from
**Southern
Water**

Our ref
PLAN-035634

Proposal: Demolition of existing dwelling & erection of replacement dwelling. This site is in CIL Zone 4 & is CIL Liable as new dwelling.

Site: M/75/20/PL: - 13 Elm Drive, Elmer, Middleton-On-Sea, PO22 6JE.

Site Plan 1:100

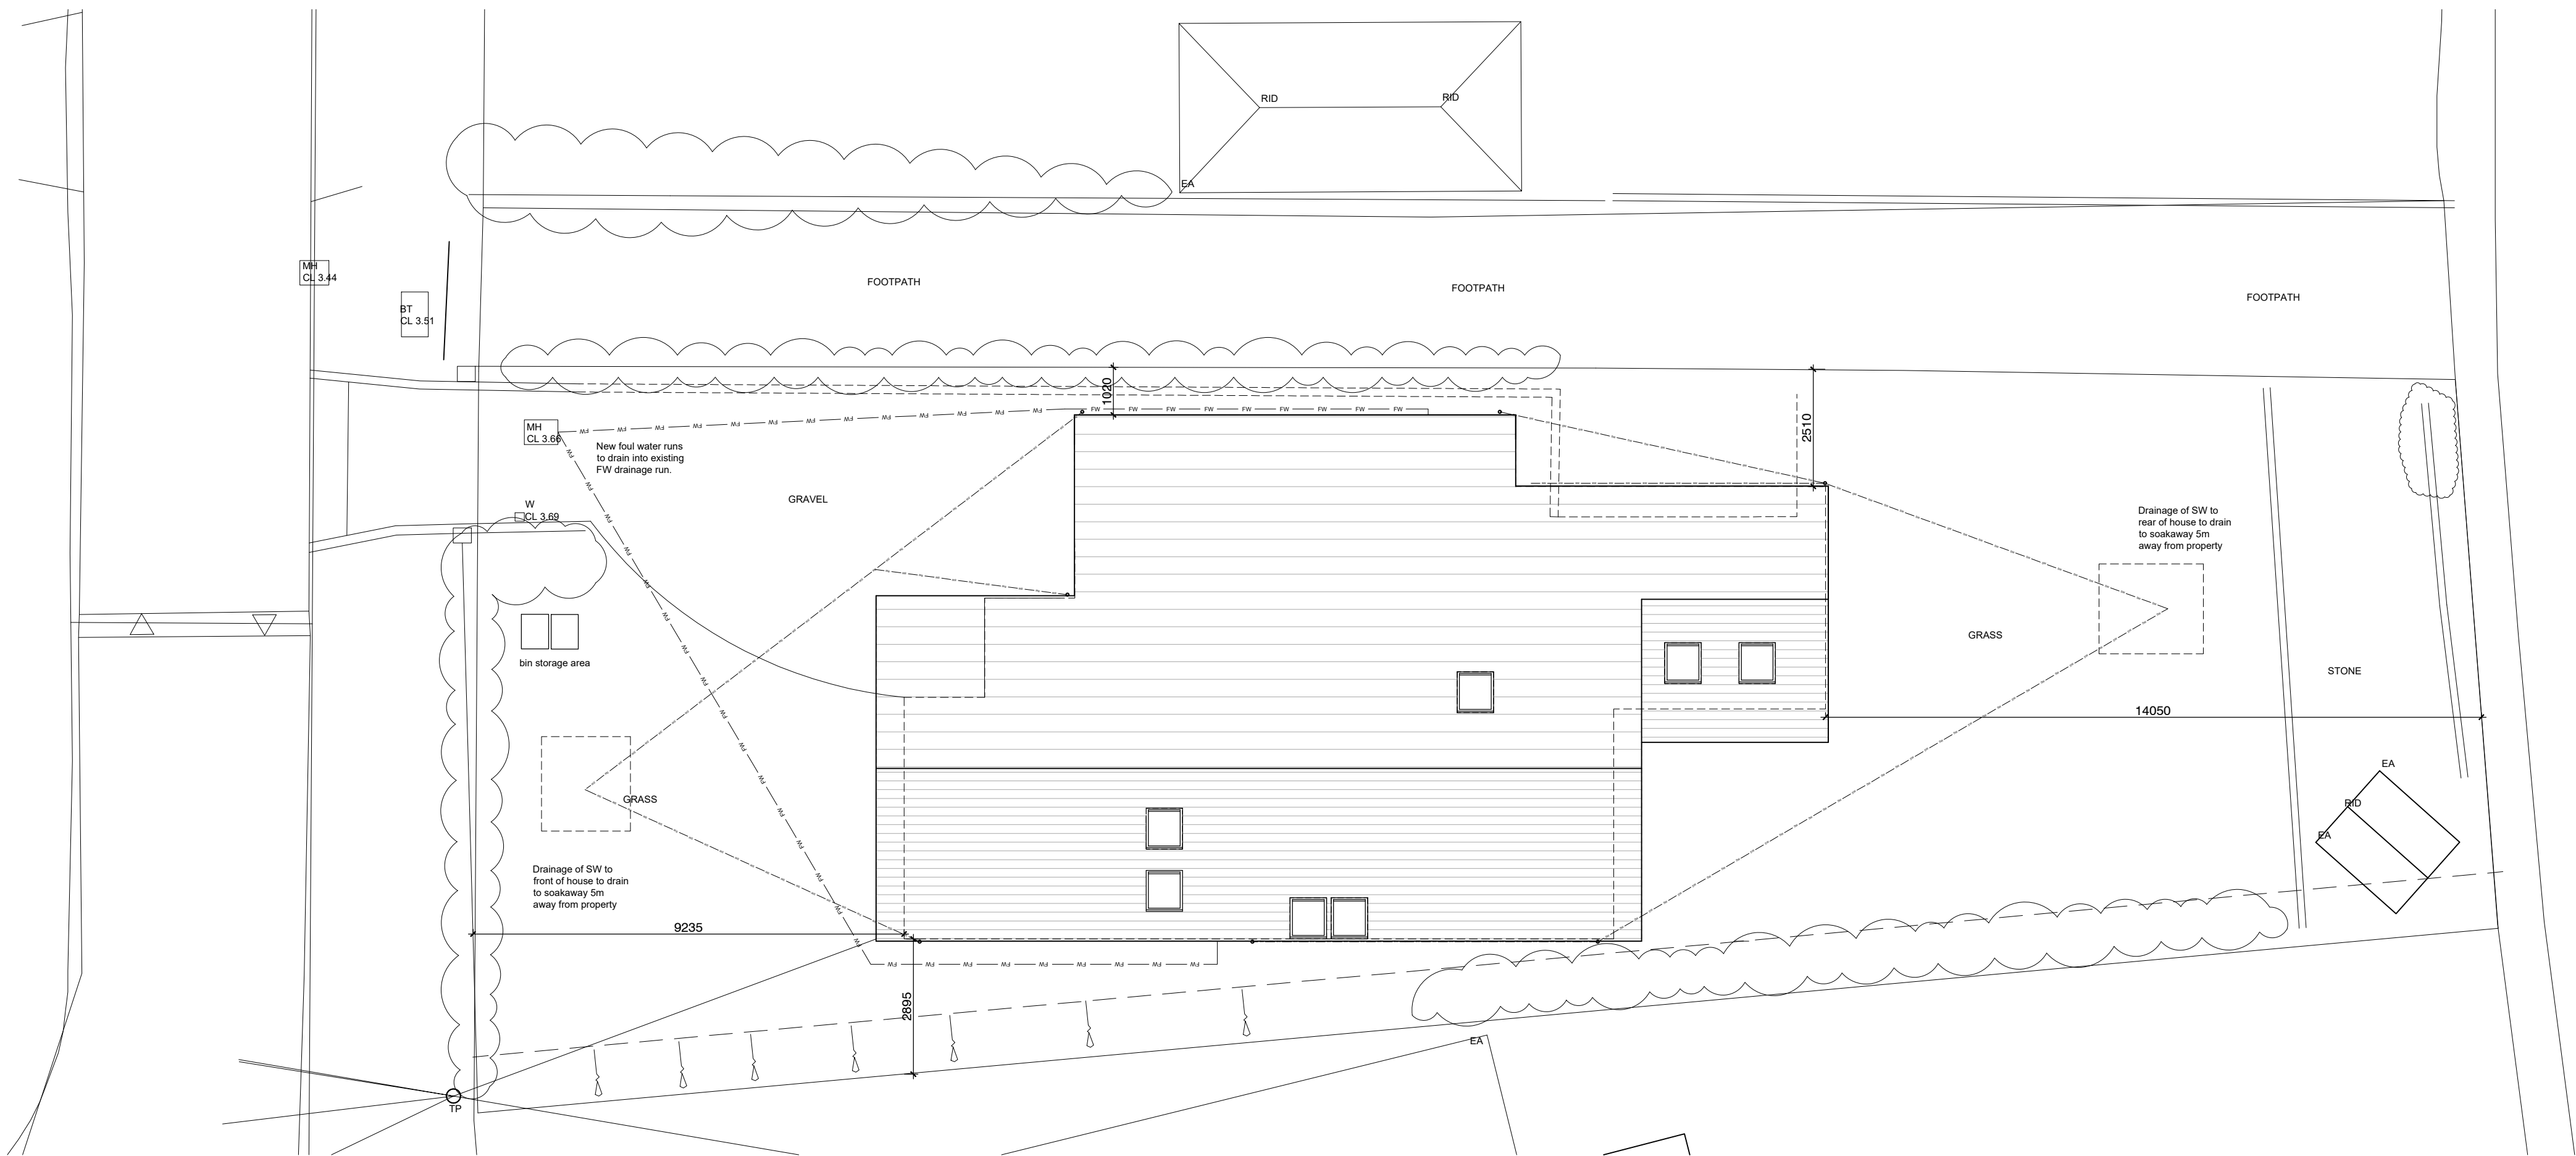
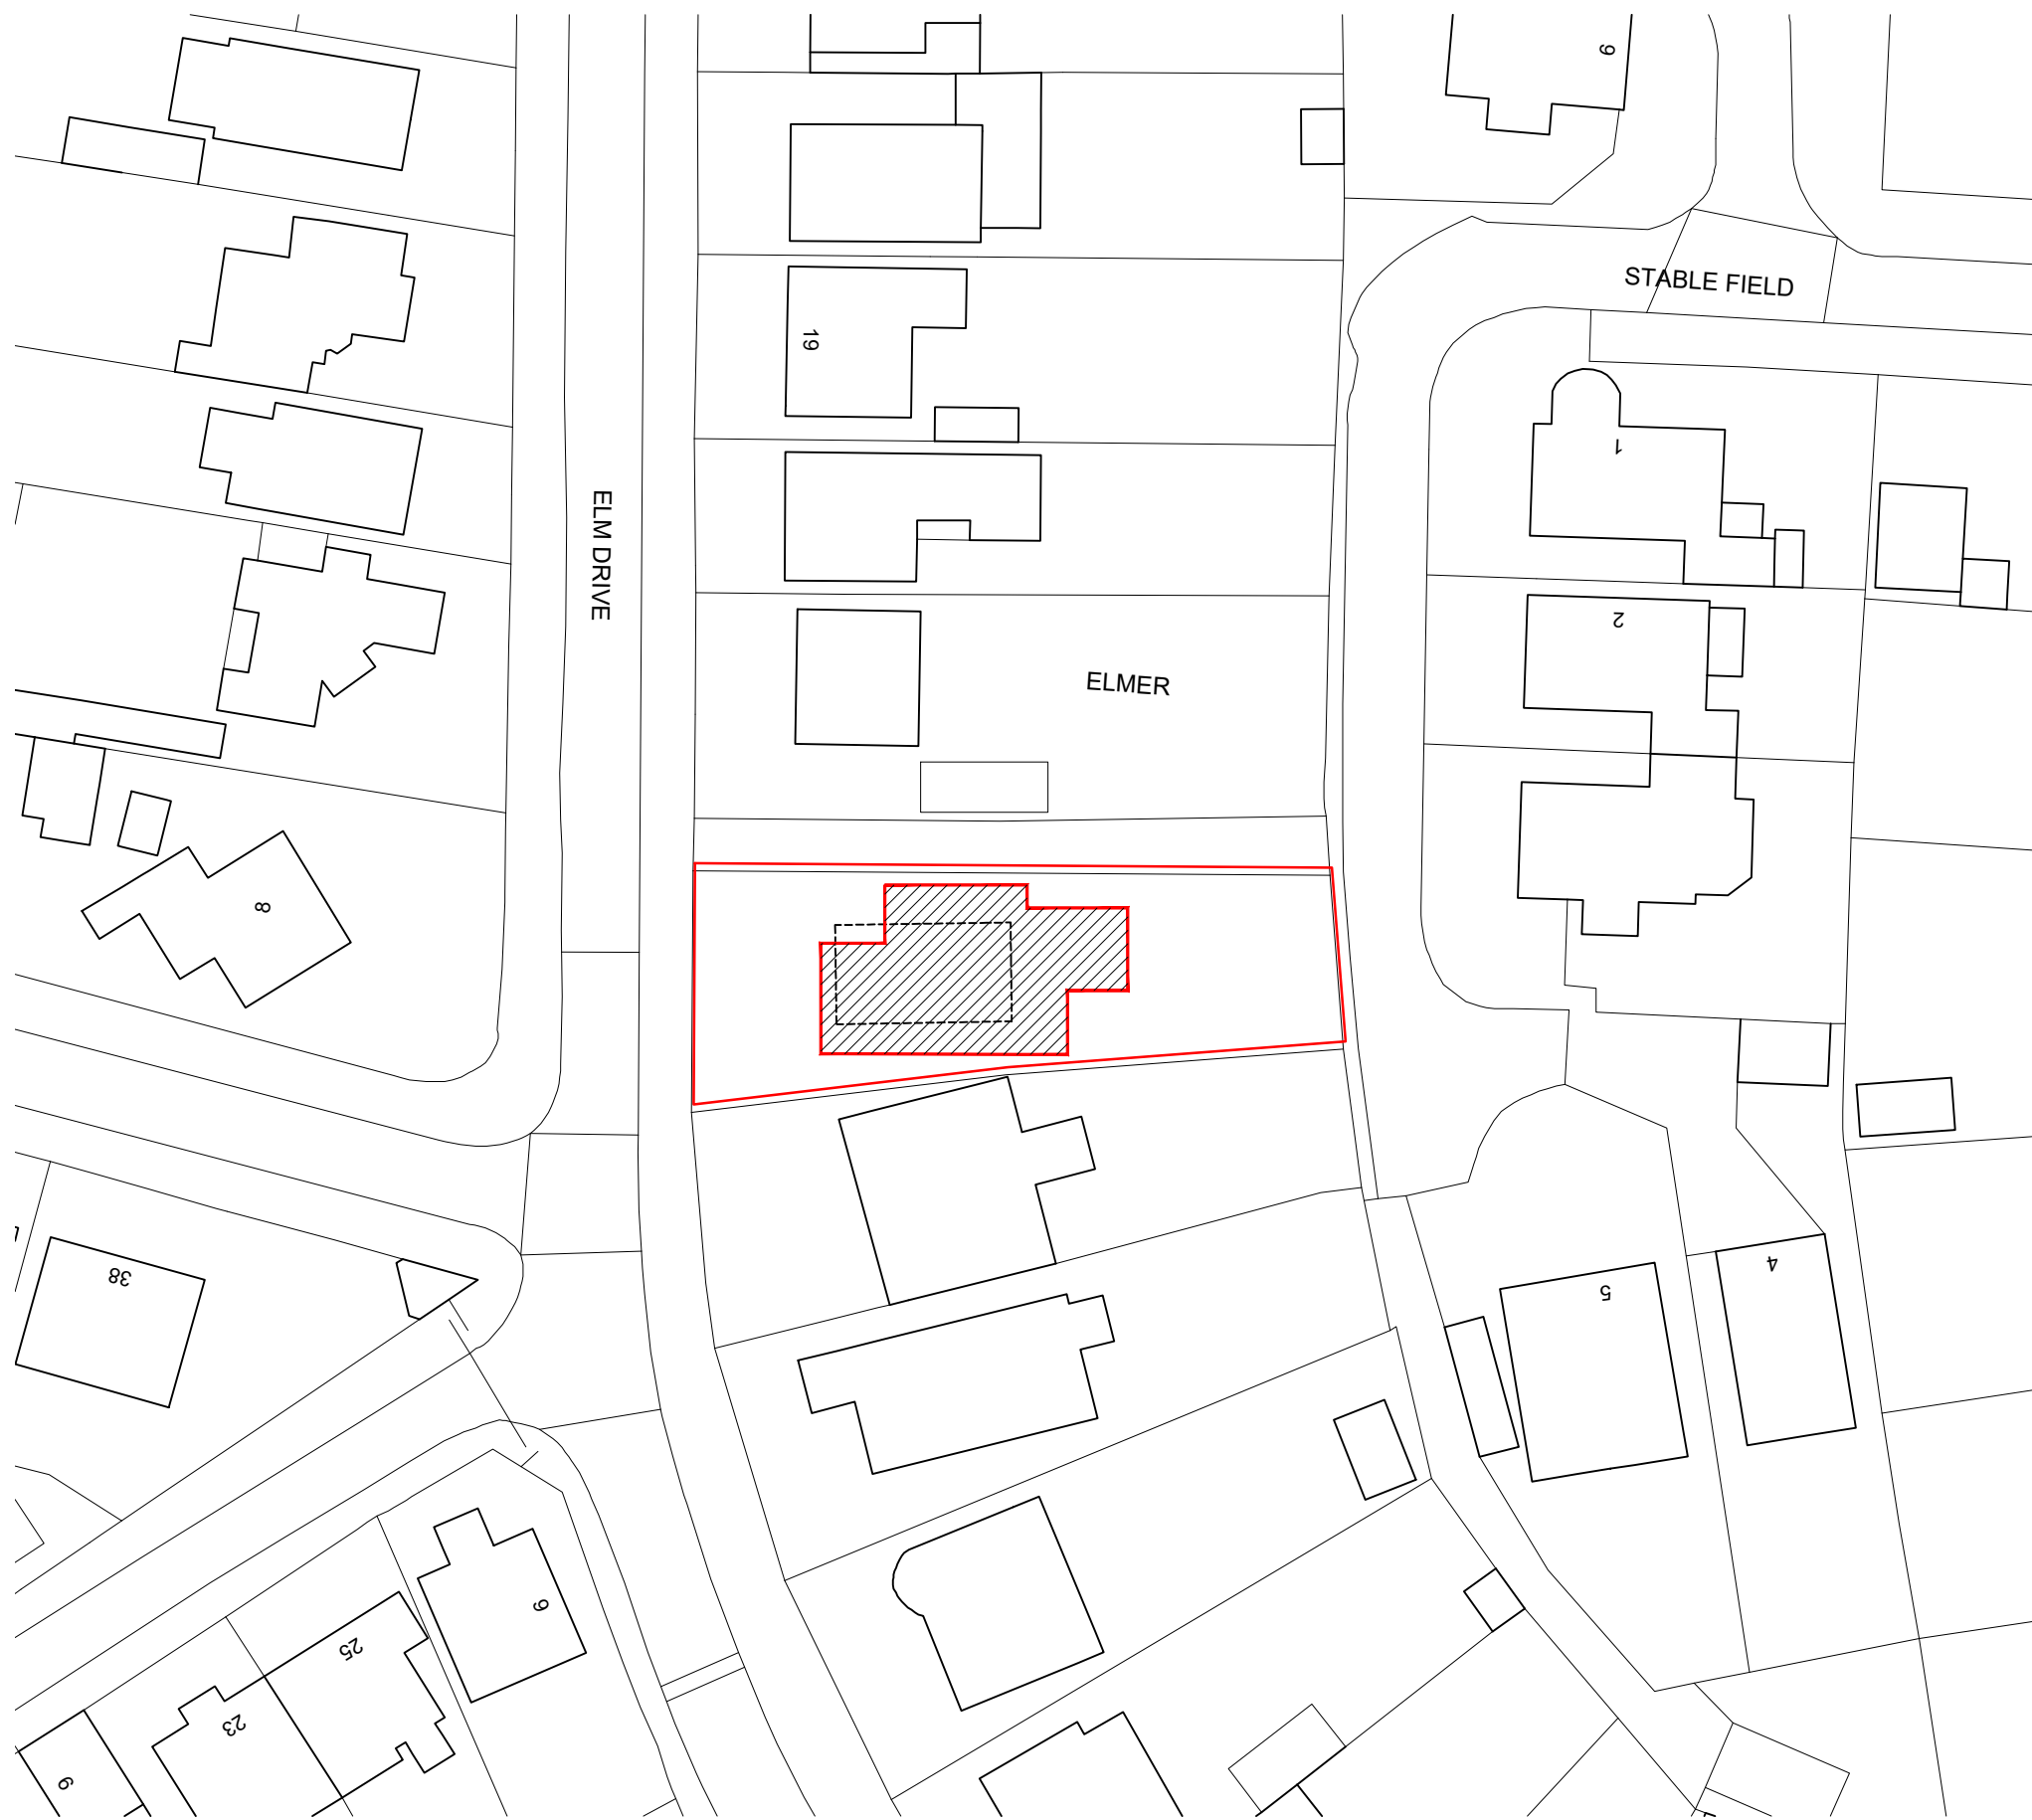
Please see the attached extract from Southern Water records showing the approximate position of our existing public foul sewer in the immediate vicinity of the development site. The exact position of the public foul sewer asset must be determined on site by the applicant in consultation with Southern Water before the layout of the proposed development is finalised.

- The 150mm public foul sewers requires a clearance of 3 metres on either side of the gravity sewer to protect it from construction works and to allow for future access for maintenance.
- No development or tree planting should be carried out within 3 metres of the external edge of the public gravity sewer without consent from Southern Water.
- No soakaway, swales, ponds, watercourses or any other surface water retaining or conveying features should be located within 5 metres of a public sewer.
- All existing infrastructure should be protected during the course of construction works.
